ATP signage SSD-7317-Mod-19

OBJECTION

Location 4, Redfern station light tower is 12-metres height of signage, immediately adjacent to residential units in the Watertower building, at a distance of 15-metres.

SITE PLAN
SCALE 1:100

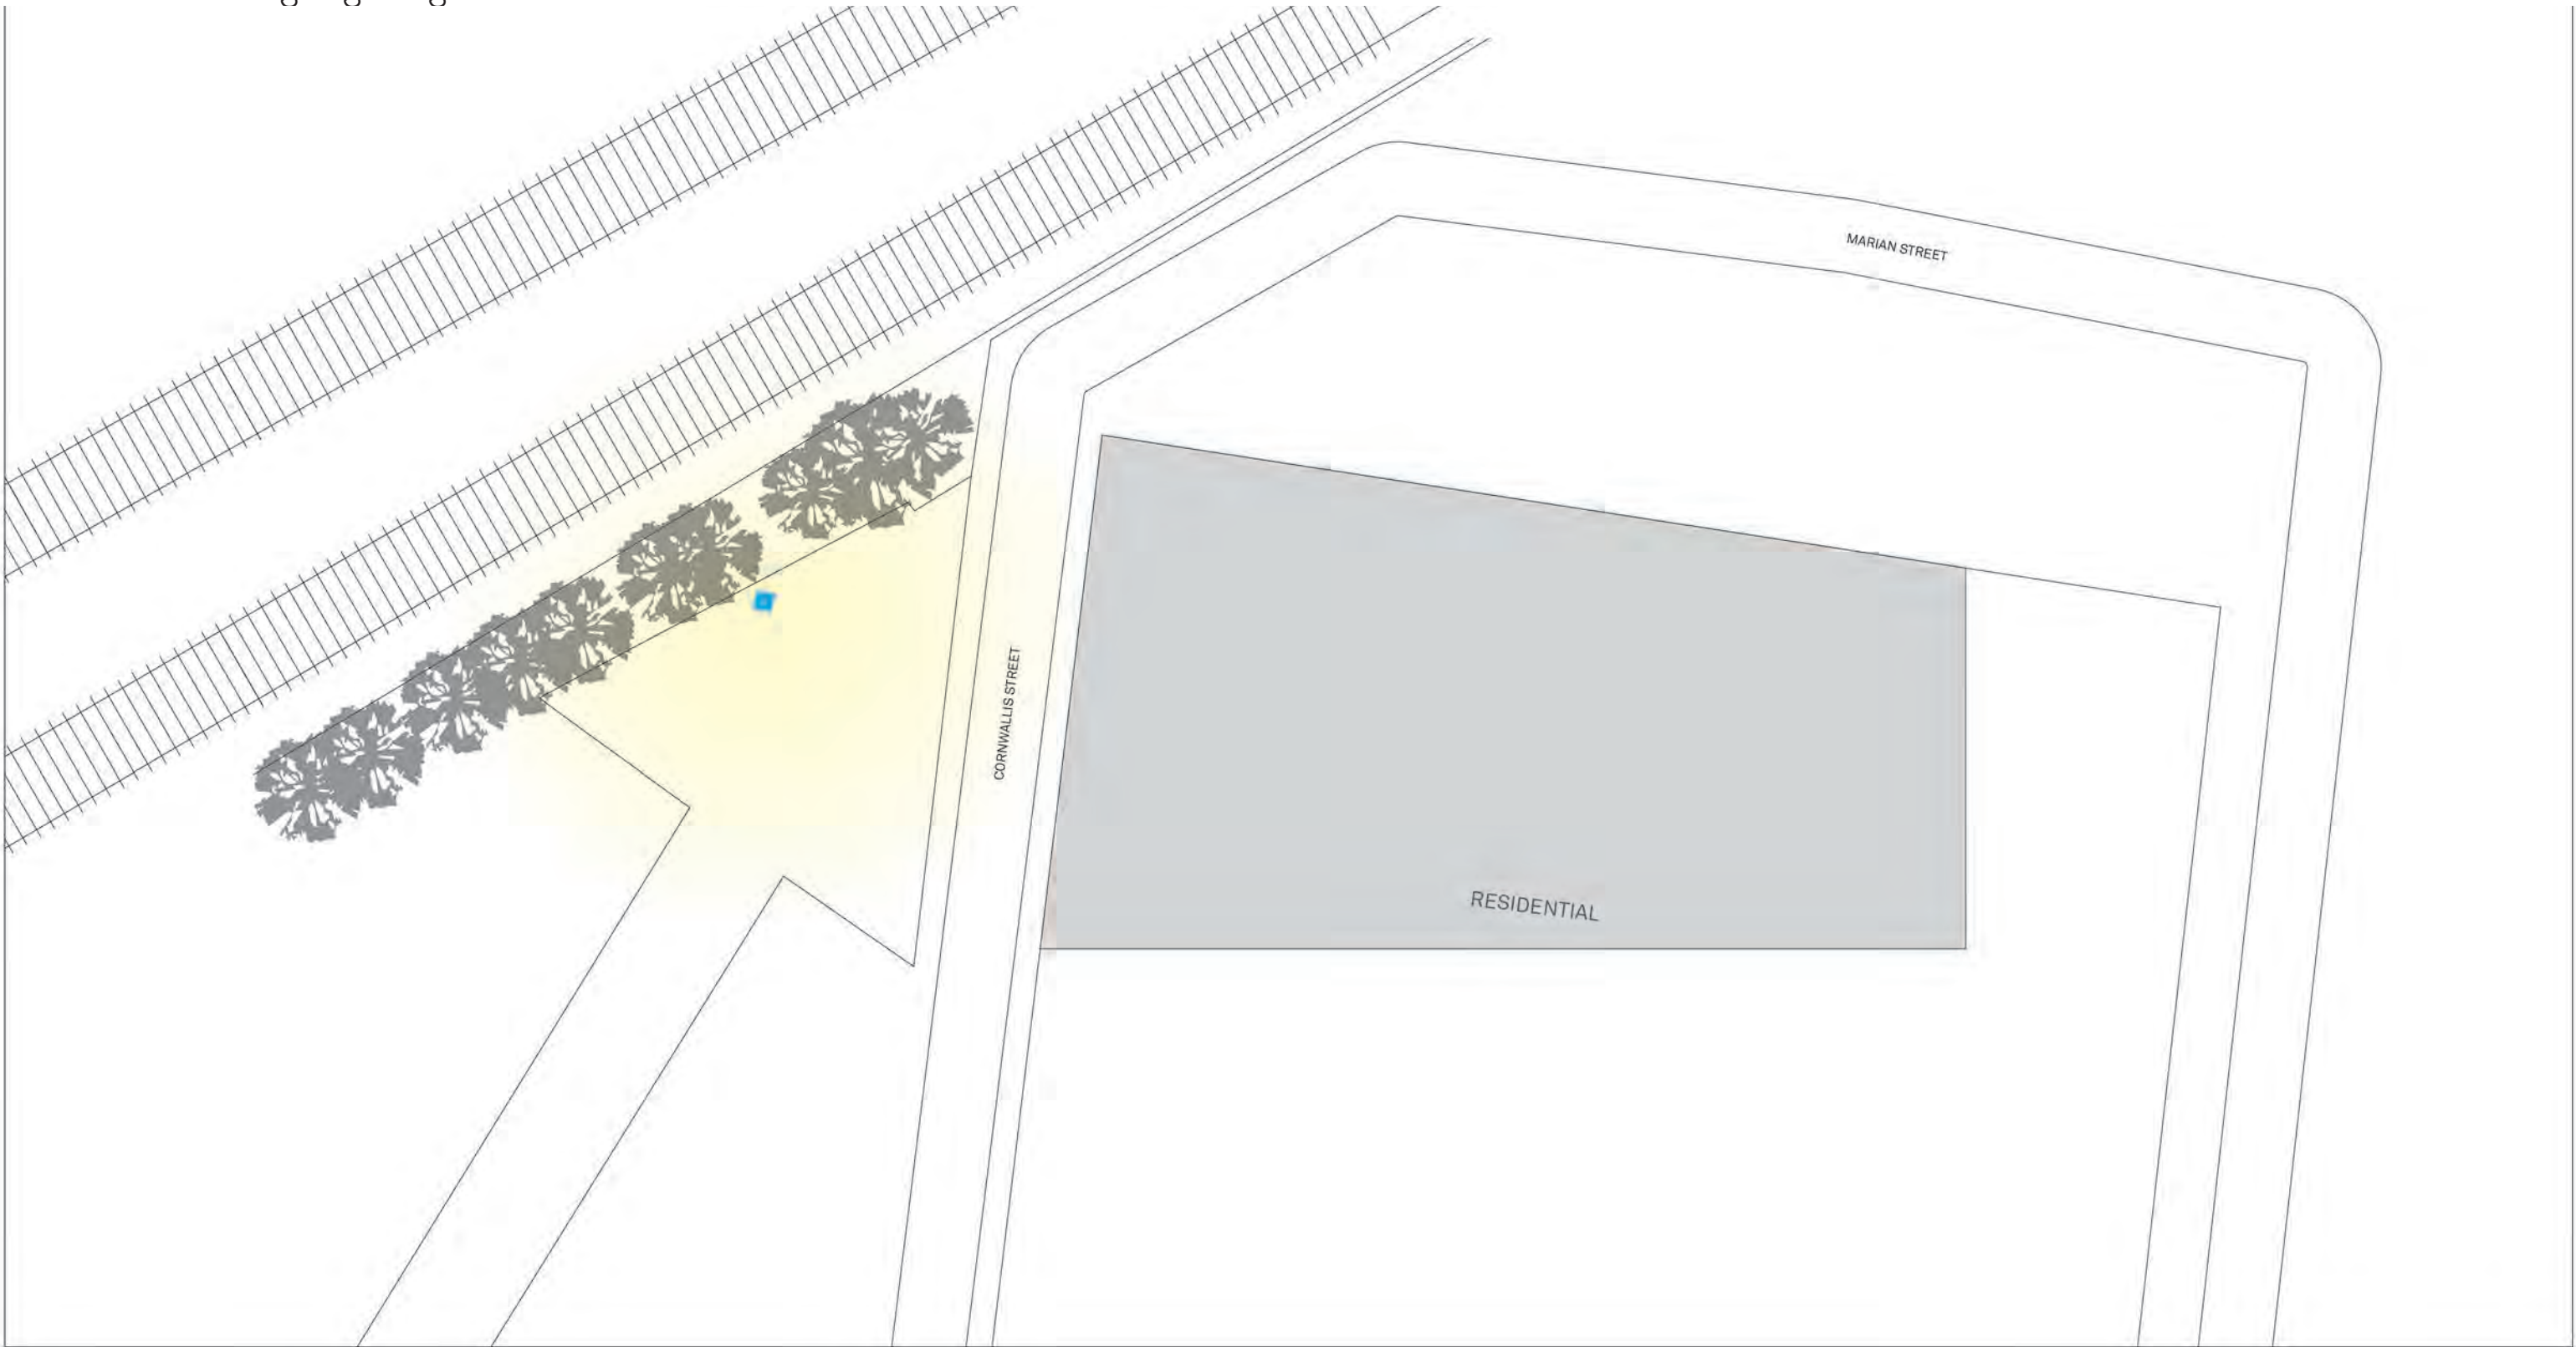
Whilst appreciating the design rational, this will not lessen the diminishing effect the tower will have on the lines of the Watertower building, a well-preserved industrial building, the first of Sydney's conversions to residential. In addition, the light emitted by the tower will

be an **unwarranted and unreasonable invasion of domestic space** within the building.
